**Ref: Planning Application R/90/18/HH
at no: 9 Park Drive, Rustington**

Further to the withdrawal of the applicant's earlier application, ref no: R/283/17/HH, and having inspected the details and plans of the applicant's revised proposals as shown on the Council's website I am writing to object to the above planning application for extensions to the existing buildings at no: 9 Park Drive, Rustington.

Proposed East Elevation

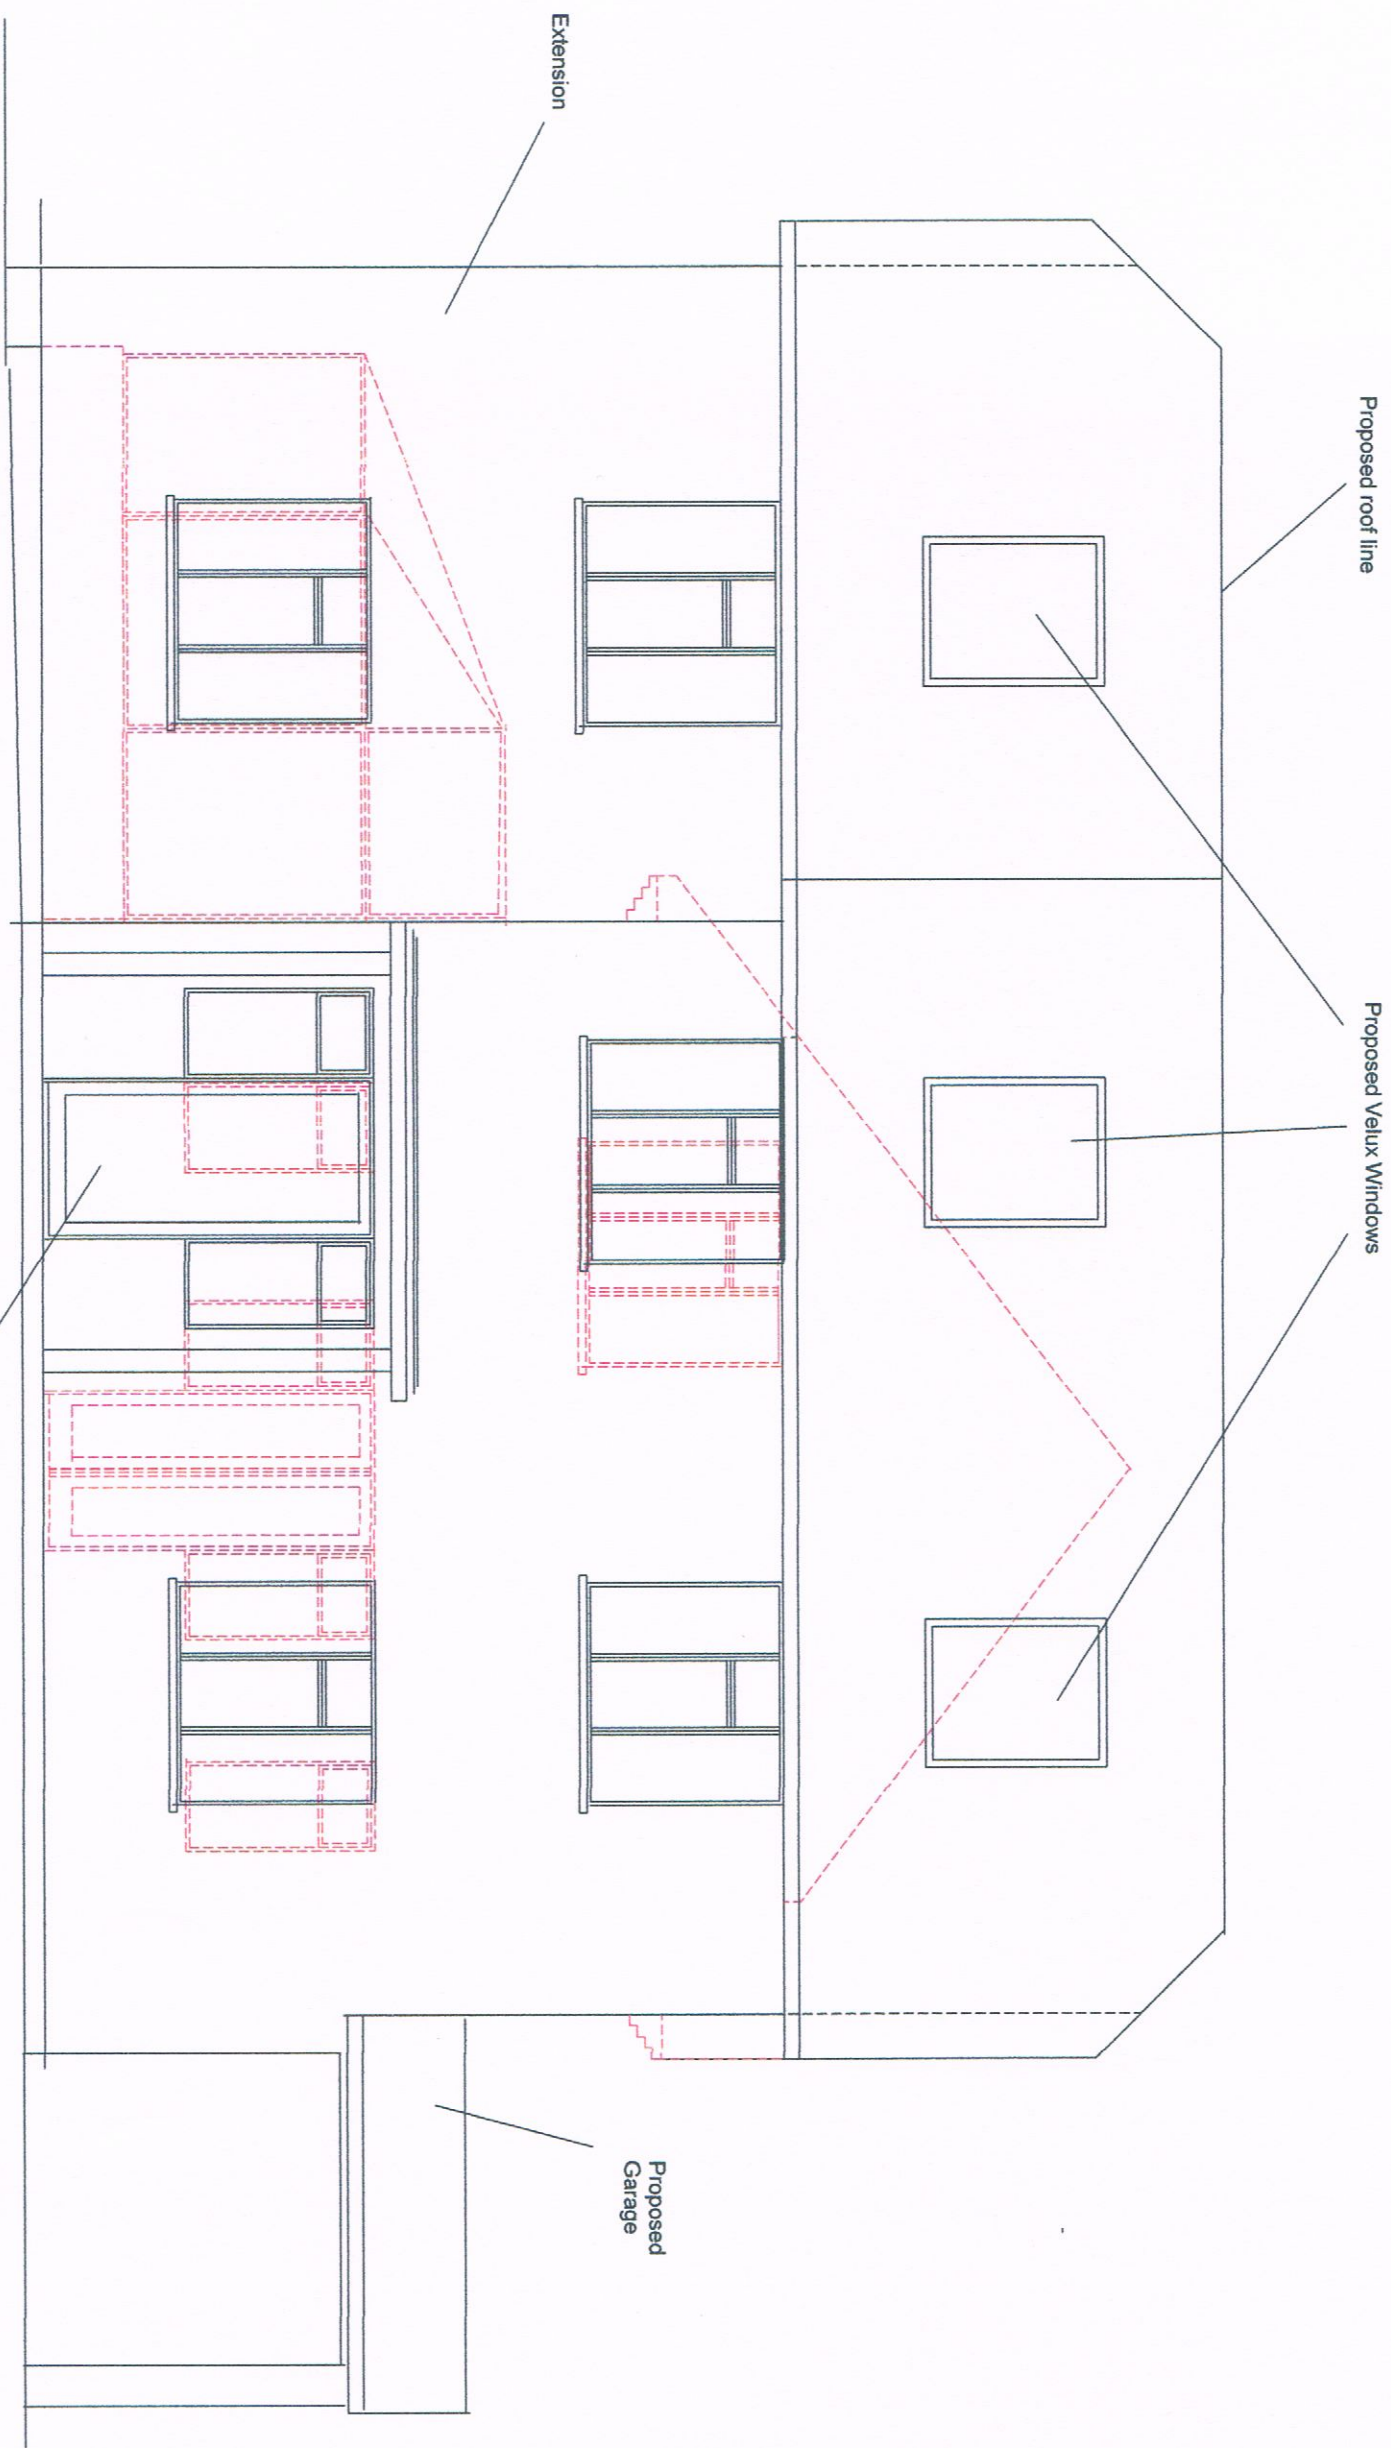
- (ii) Visual subservience to the existing building – the front ie east elevation of the proposed house shows that the proposed building has an area of some 50% more than the existing building. Such a major enlargement cannot be said to be subservient to the existing building. Further it is difficult to envisage how any three storey extension of this magnitude could ever be seen as visually subservient to the original property.
- (iii) Overbearing effect and appearance – the extra height of the roof and the greater area of the roof over the longer re-orientated roofline axis will present the appearance from the street, Park Drive, of a significantly larger frontage to the extended house than the existing one. The extra height, even with a small hip, will similarly affect those looking at the extended house from their flats on the northern side of Herne Court.

The sheer scale of the development would be overbearing and its eastern elevation would be intrusive to the neighbours especially those on the opposite side of Park Drive, in Herne Court and in St Anthony's Way.

Proposed Roof Plan

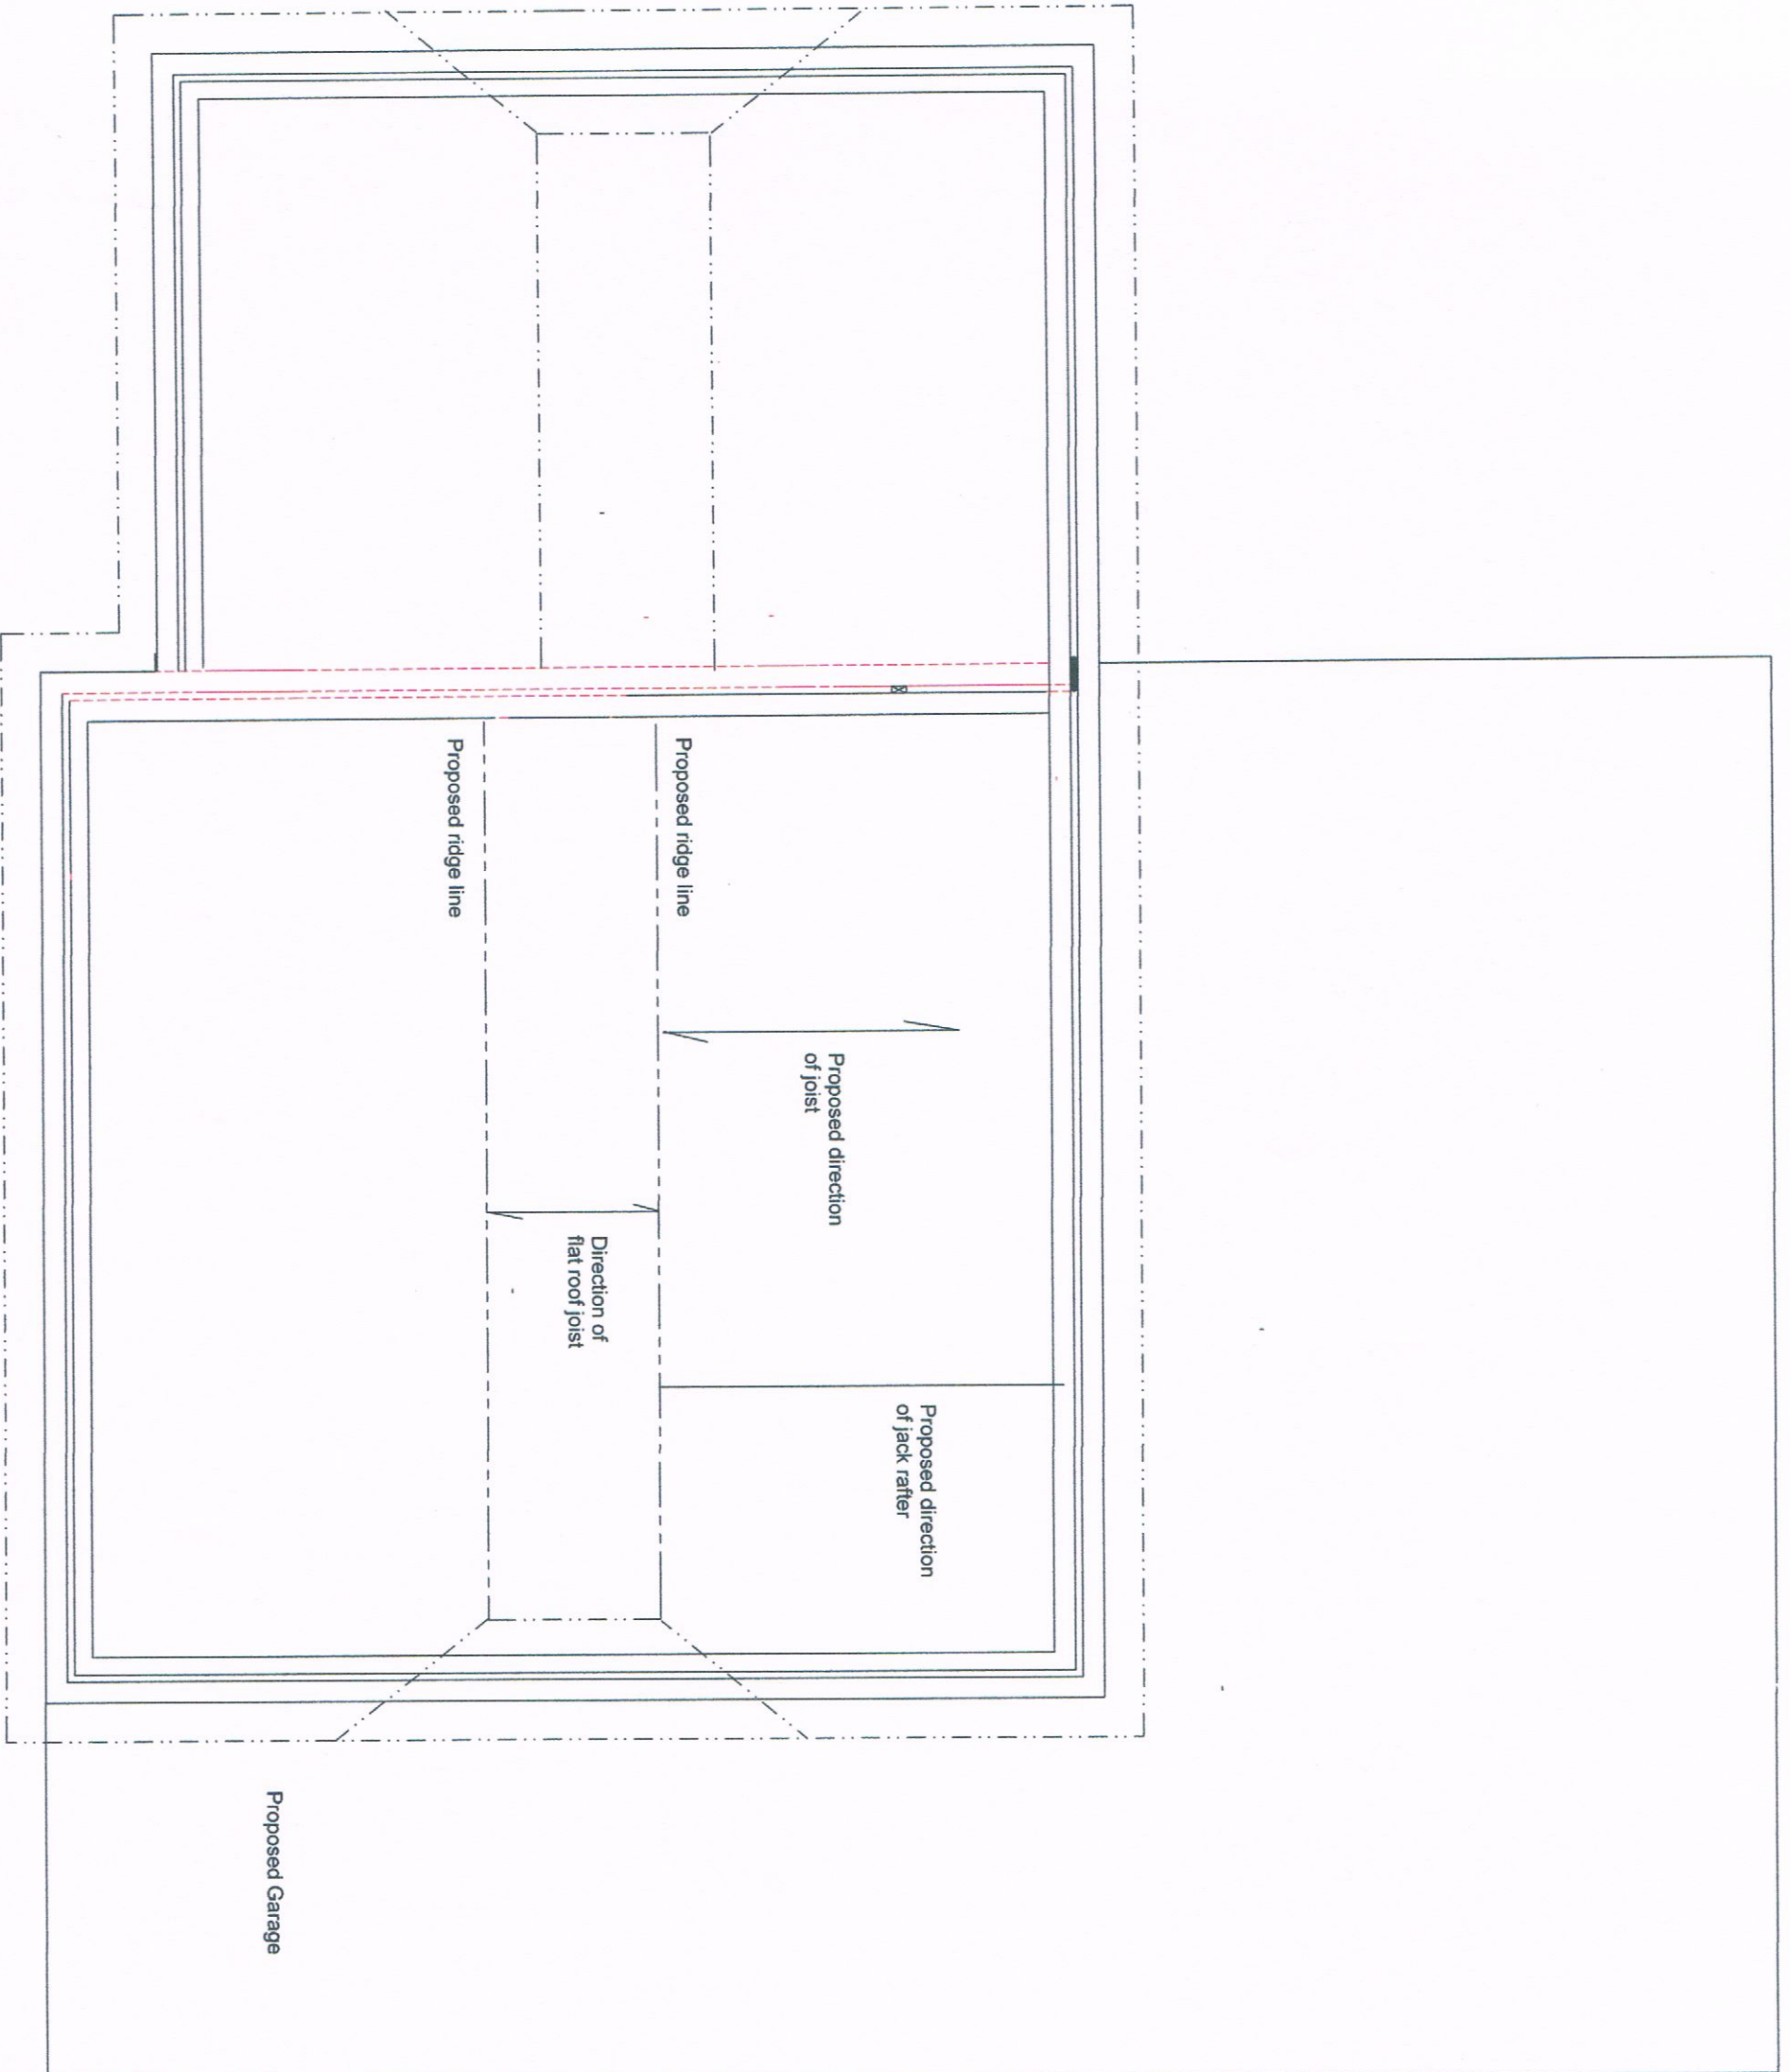
- (iv) Relation to established spatial character and pattern – the three windows in the roof at both the front and rear of the proposed extension creates both the fact and the appearance of what would be the only three storey house in the road. The extension would also have such a wide frontage of roof slope as to be more like a small office block than a house and wholly out of character with the rest of the properties in this part of Park Drive. The mass of the enlarged building would amount to an over development of the site.
